STATE OF NORTH CAROLINA
DEPARTMENT OF TRANSPORTATION

February 16, 2006

Subject: **APPLICATION REVISION for Individual Section 404 and 401 permits for TIP R-2616** for the proposed widening of US 601 from the South Carolina State Line to north of Marion Lee Road (SR 2105) south of Monroe in Union County; NCDOT Division 10. Federal Project No. STP-NHS-601(4), State Project No. 8.1690303, WBS Element 34485.1.1.

SITE 12 -L- STA. 250+00

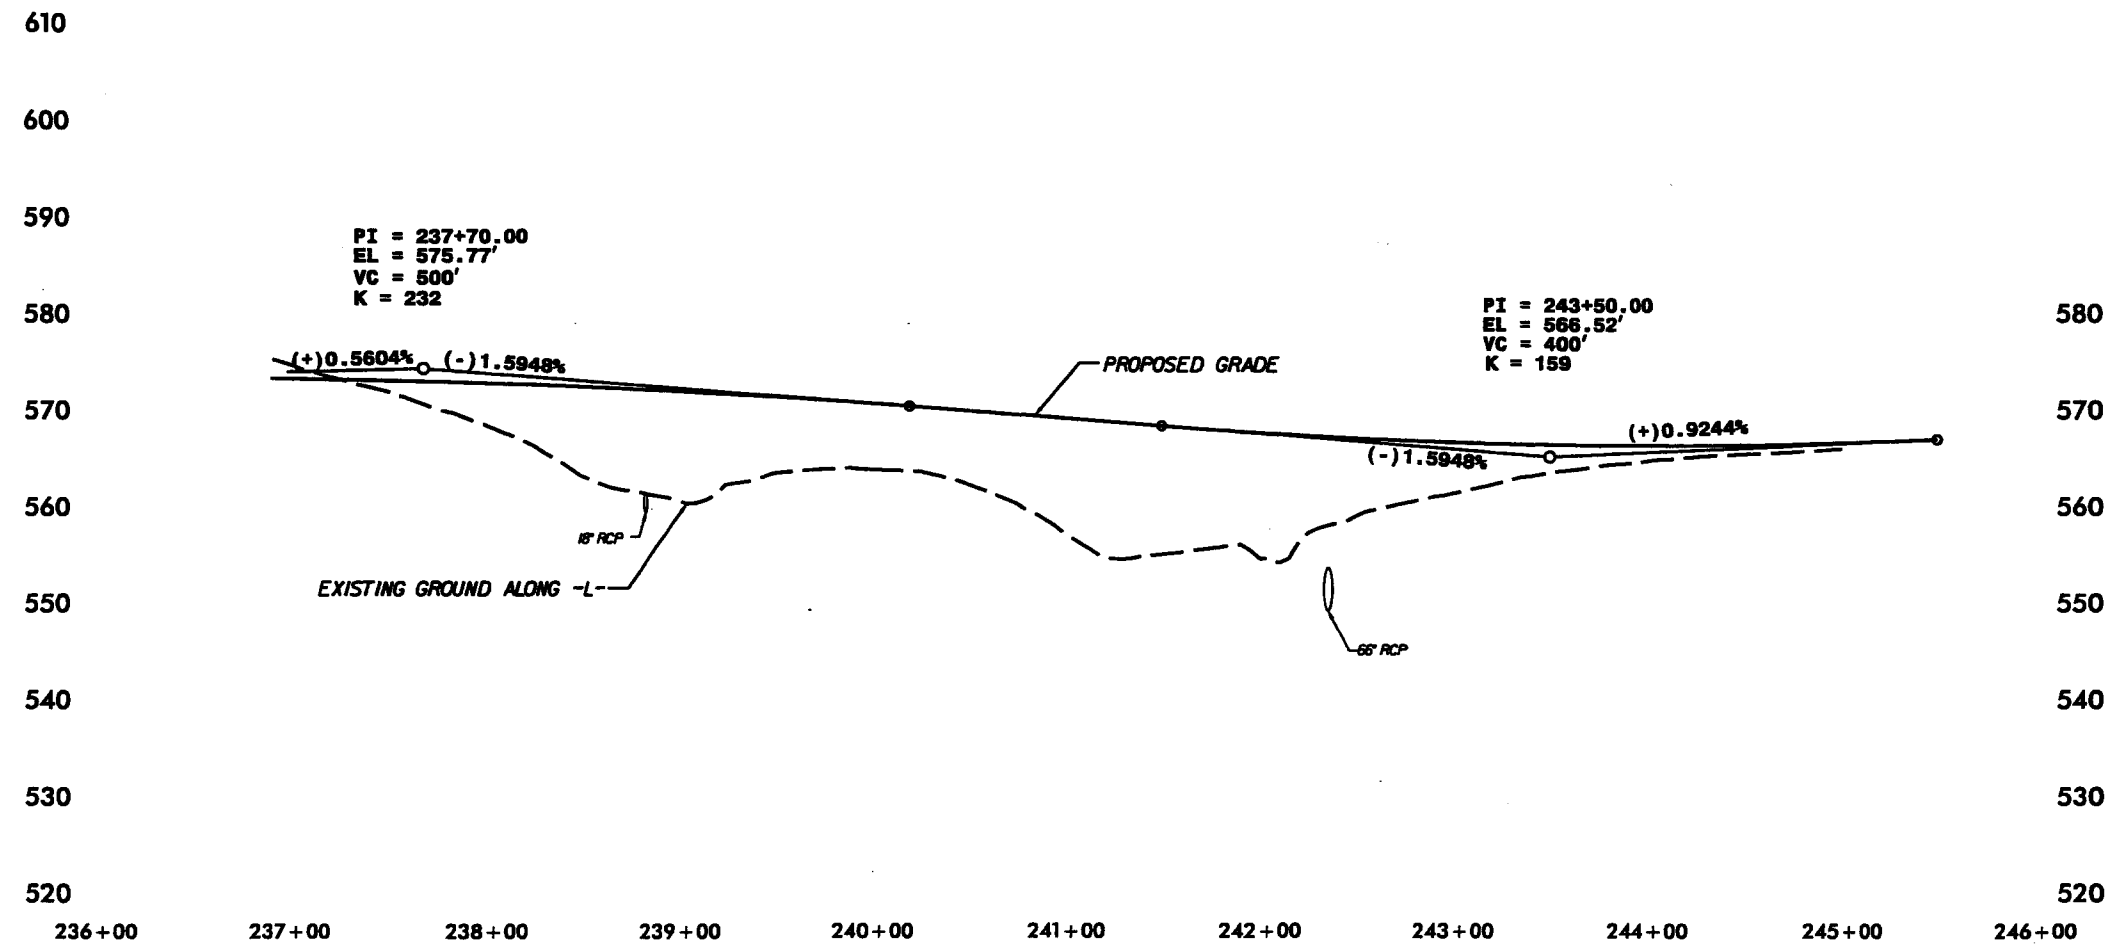
Site 12 (Permit application page 27): The permanent stream impacts have been reduced by 30 feet (from 320' to 290') due to a calculation error.

SITE 16 -L- STA. 315 + 56

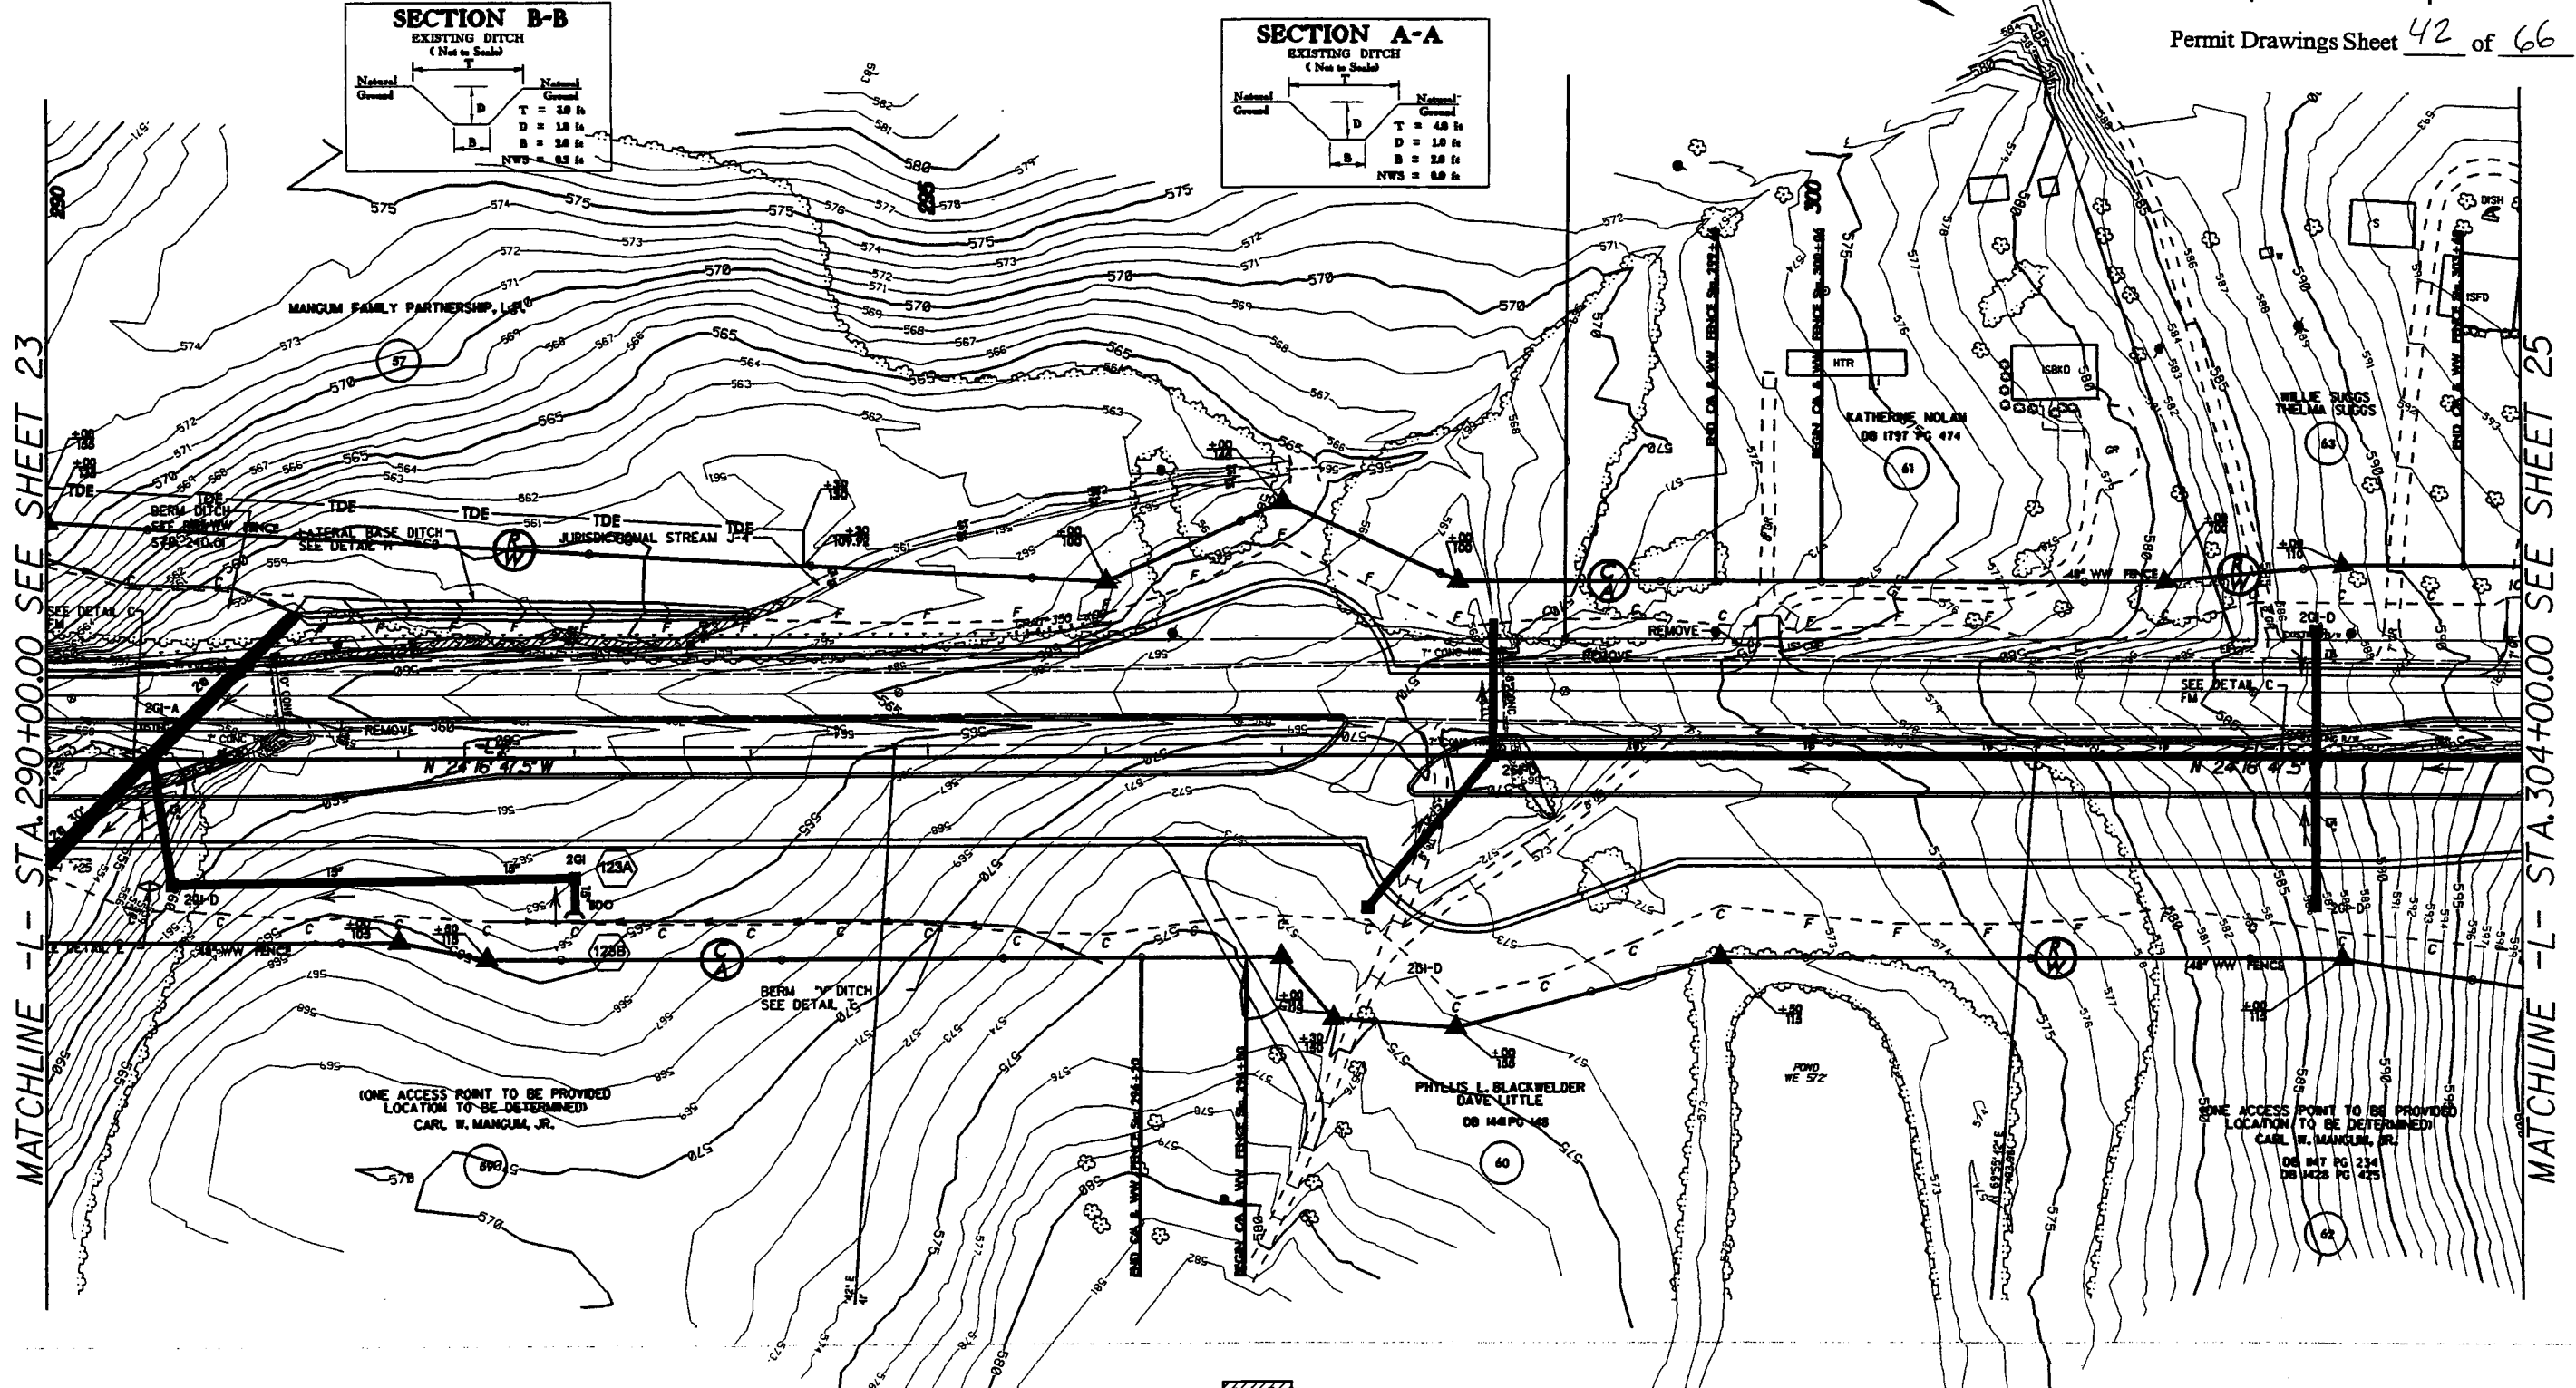
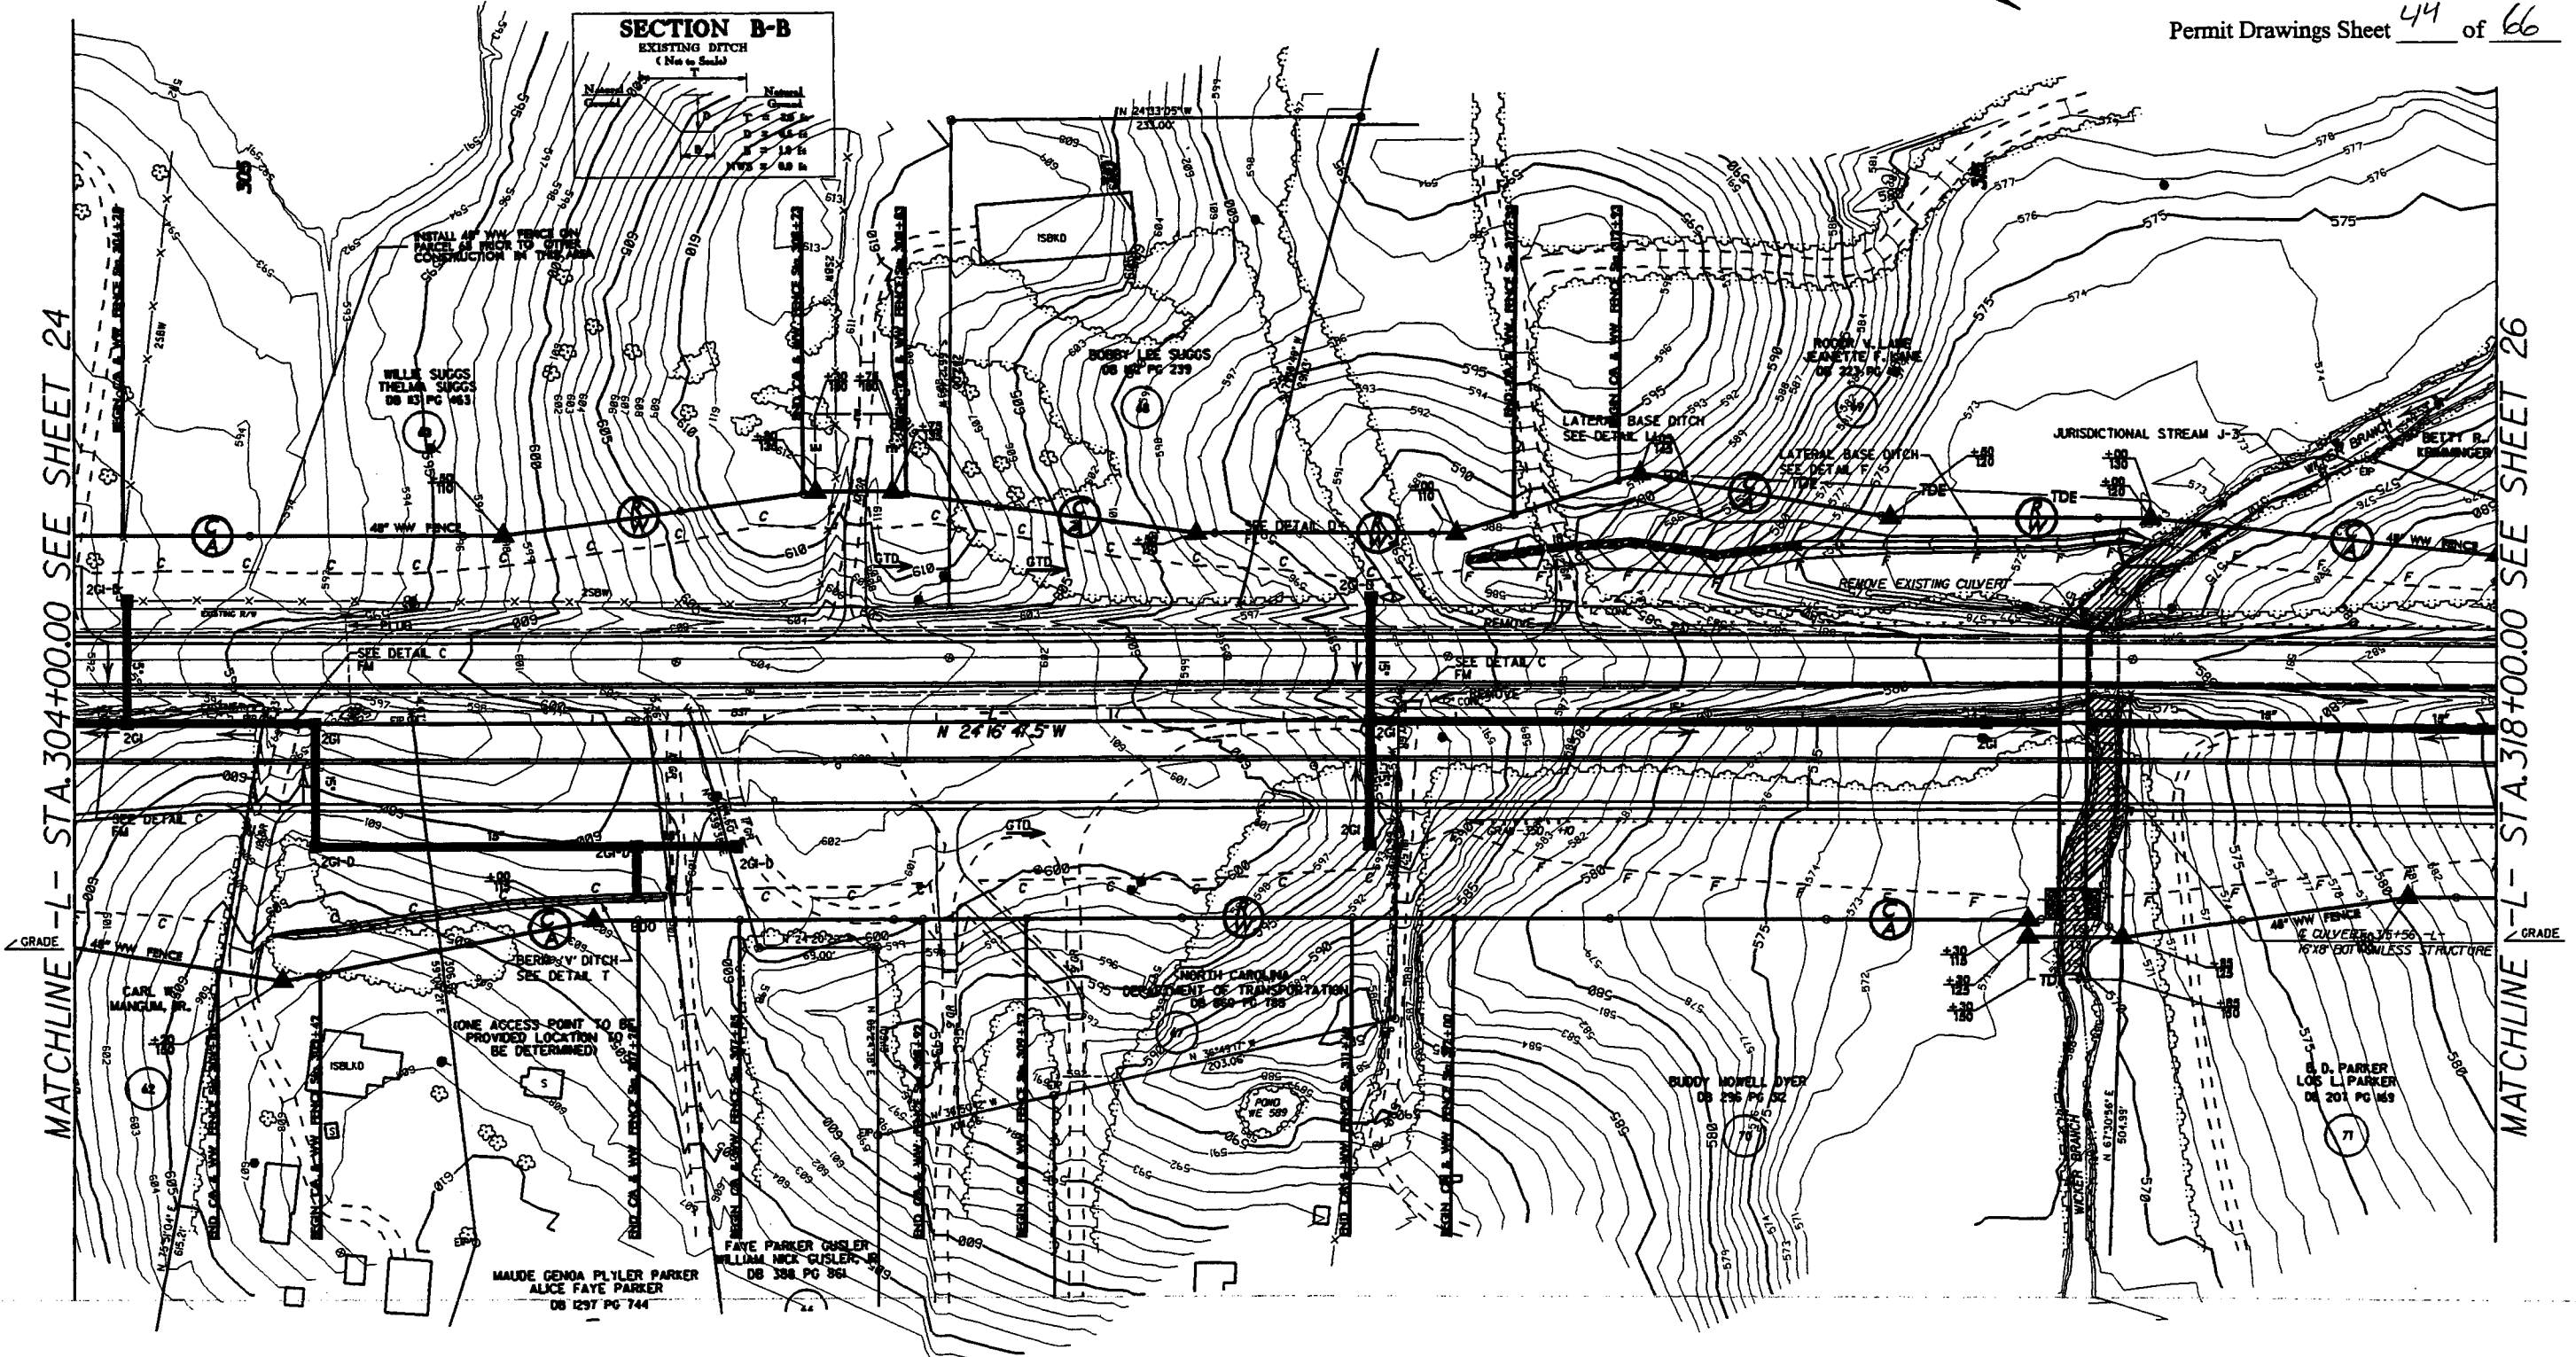
Site 16 (Permit application page 37): Due to the installation of a bottomless culvert, we have subtracted 40 feet of permanent stream impact, which will flow on natural substrate.
